District: Cherwell

Application No: 21/01224/OUT

Proposal: Outline planning application for Automotive Experience Quarter comprising Commercial, Business and Services uses (Class E), Light Industrial (Class B2), Local Community and Learning Uses (Class F) and vehicle circuits (Sui Generis) with all matters reserved aside from that of access).

Transport Development Control

job title: Bicester Motion  
 Brand Experience Application  
 drawing title: Proposed Access

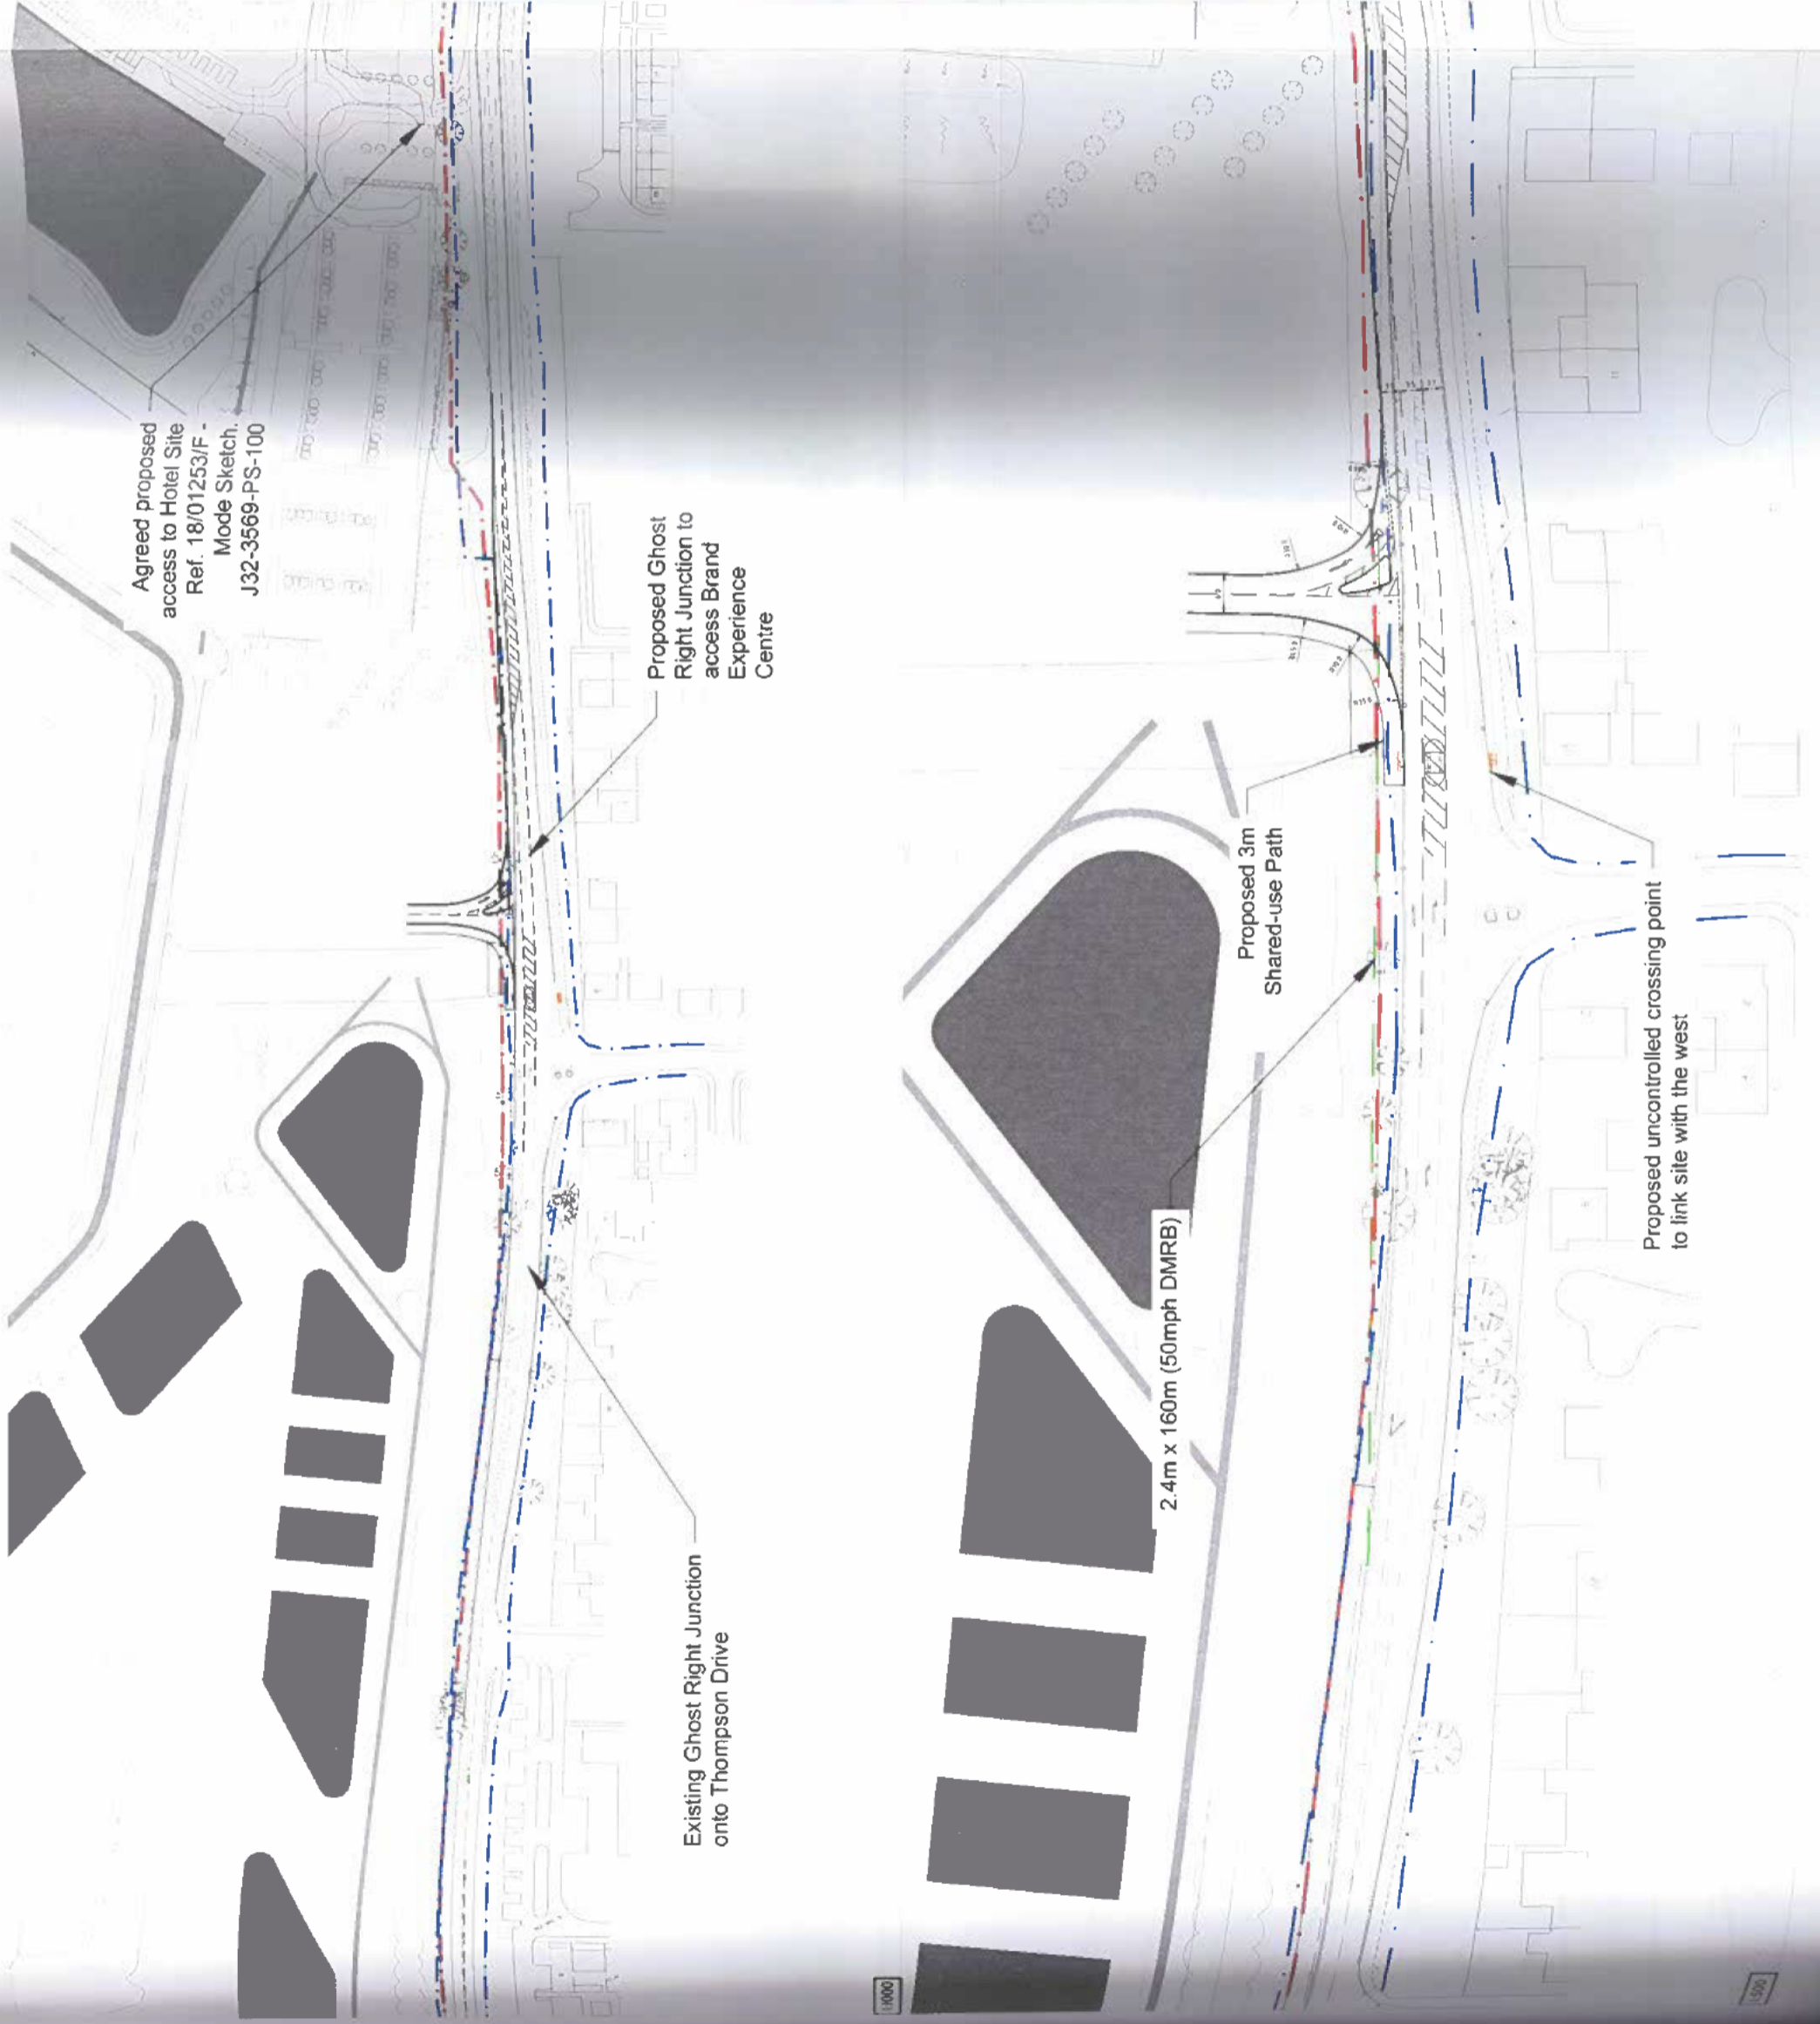
A swept path analysis has been submitted which demonstrates that a 12m rigid vehicle would be able to safely enter and exit via the two access junctions. However, it is unclear whether any larger vehicles (e.g. refuse vehicles) could be accommodated these junctions, the vehicle tracking is fairly tight at the primary access junction. The note states that a 12m rigid vehicle is expected to be the largest vehicle required to access the site, so it is assumed that refuse collections from Bicester Motion will be using smaller than average refuse vehicles. A planning condition is requested to ensure that the detailed layout of the primary access junction is agreed prior to commencement of development.

- Ø Site access junction from the A4421 Buckingham Road as shown indicatively in Drawing No. J32-3684-PS-201. Pedestrian and cycle facilities, connections and crossings at the site access junction to be agreed with OCC.
- Ø Improvements to / reinstatement of the site access junctions along Bicester Road (to Stratton Audley) including safe pedestrian and cycle access. To be agreed with OCC.
